**EXISTING SEPTIC SYSTEM INSPECTION**

Address: 1986 NEIGHBORS RD DUNN N.C. 28334

Purpose of Inspection: 18' x 18' x 48" Above Ground Pool

Drawing file: BRES2306-0017 / REF ATO SITE PLAN.pdf

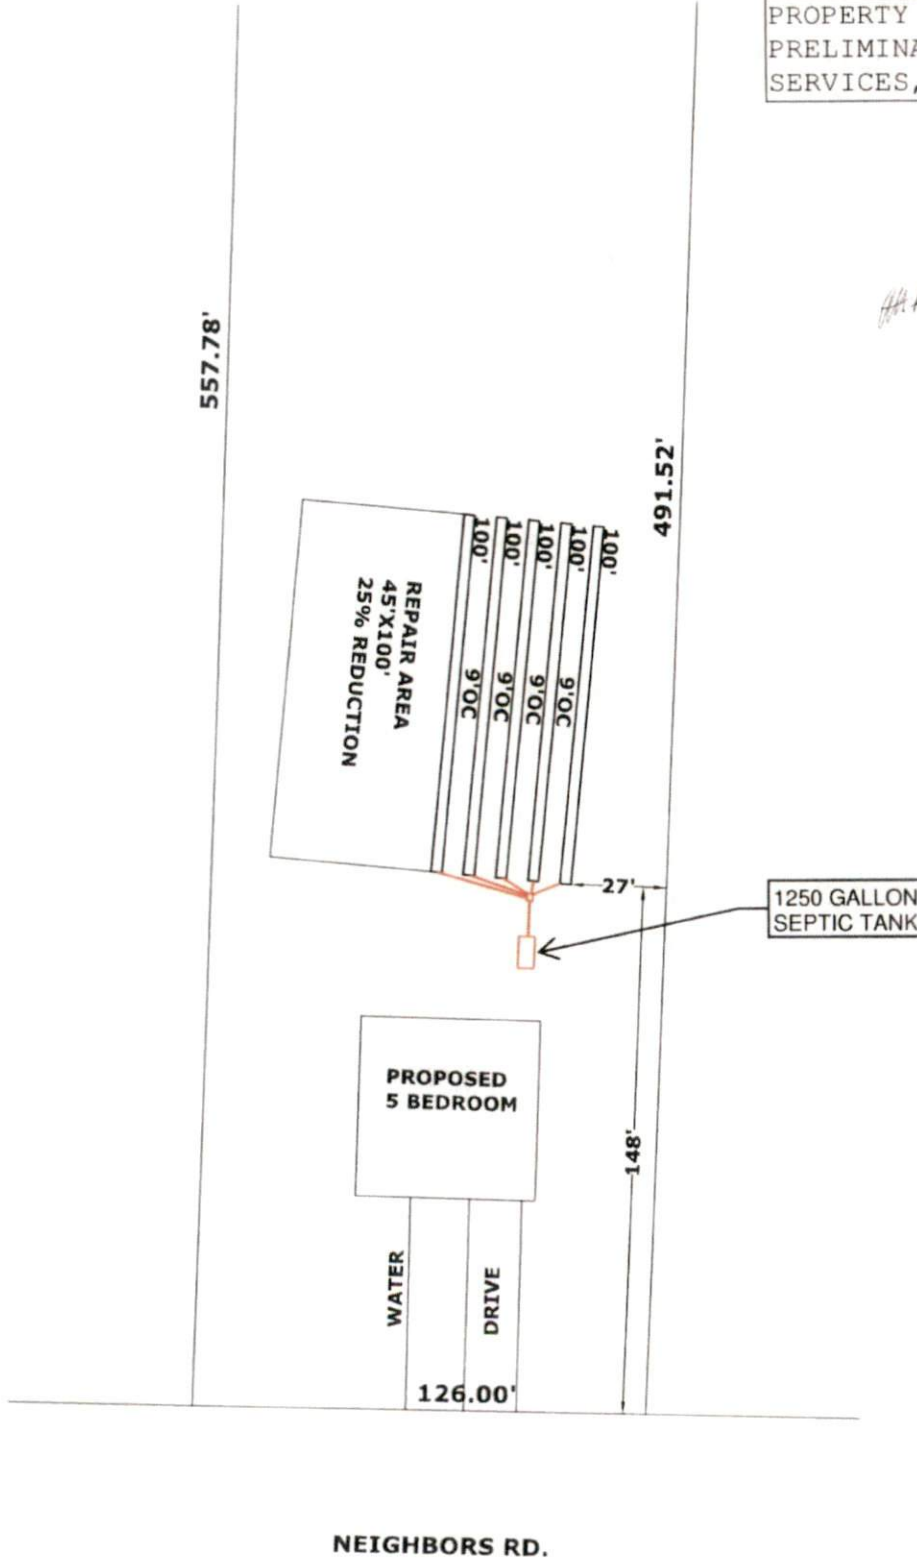
*\*Spoke with owner about pool being 12' off of septic manholes - Advised to move over toward P/L and back toward S/D*
